**KIRKLEES METROPOLITAN COUNCIL
INVESTMENT & REGENERATION SERVICE**

DELEGATED DECISION TO DETERMINE PLANNING APPLICATIONS

Reference No:	2023/62/93293/W
Site Address:	8, Cockley Meadows, Kirkheaton, Huddersfield, HD5 0LA
Description:	Demolition of existing conservatory and erection of single storey rear and side extensions and formation of undercroft garage with associated engineering works to form access from Cockley Meadows
Recommending Officer:	Laura Yeadon

Officer Report

AS PROPOSED_ ELEVATIONS

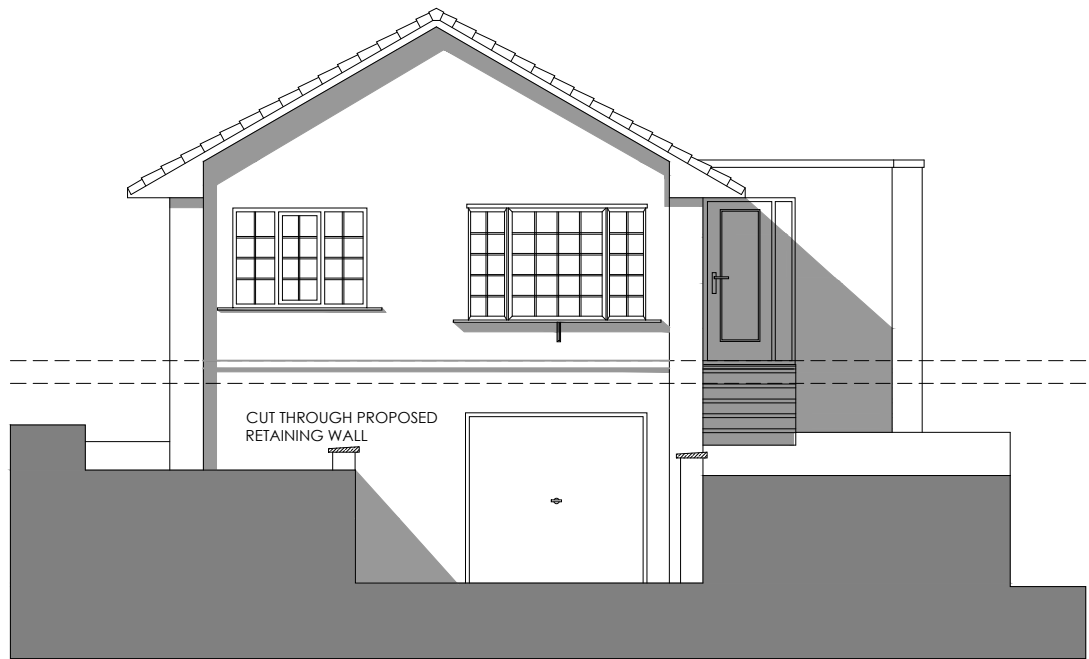
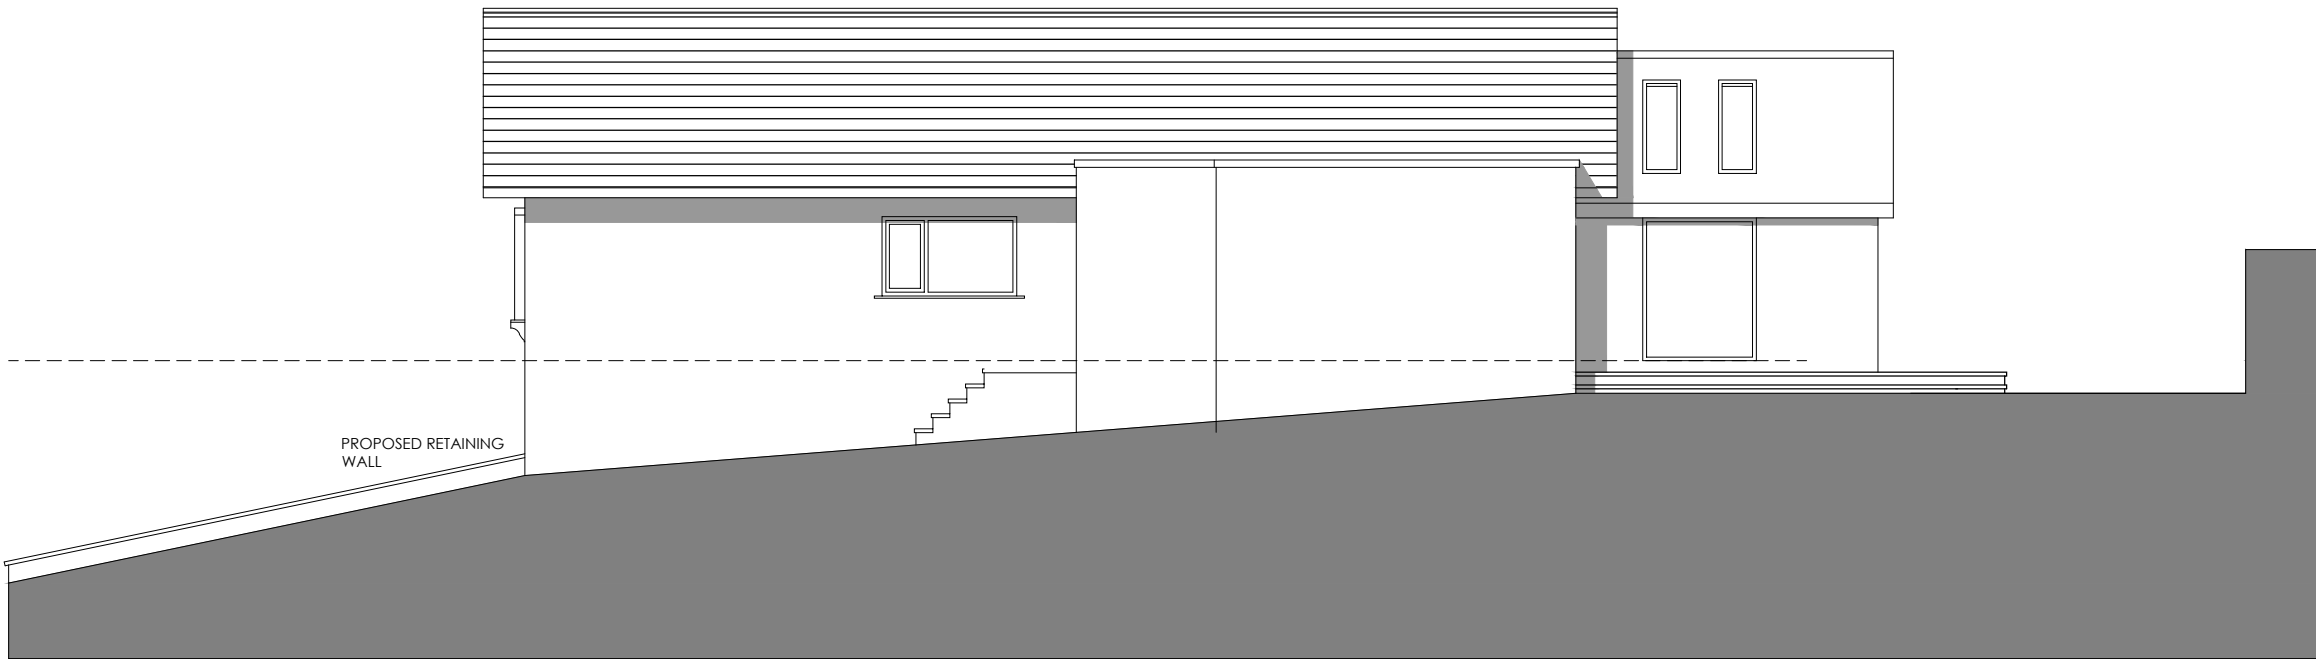
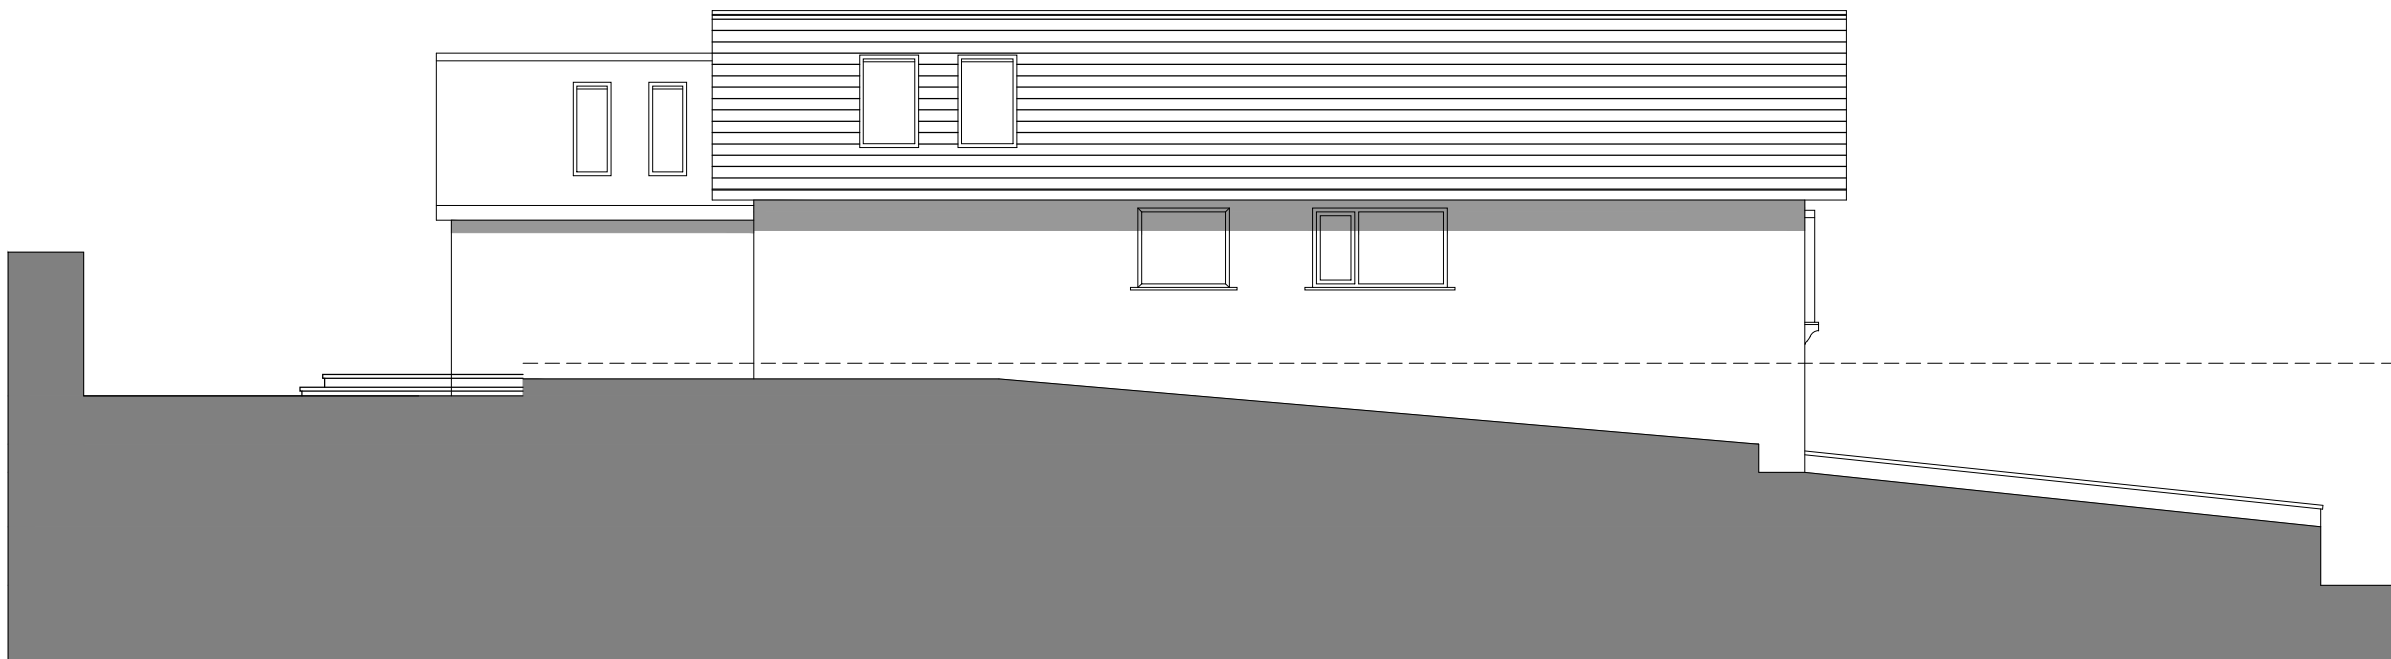
The proposed single storey side extension would be set back from the front elevation of the property by more than 0.5 metres being set back by approximately 7.2 metres, it would not exceed 4 metres in height and would not extend more than two-thirds of the width of the original house. The walls of the extension would also match the host property and therefore, this element of the scheme would also comply with the requirements of the SPD.
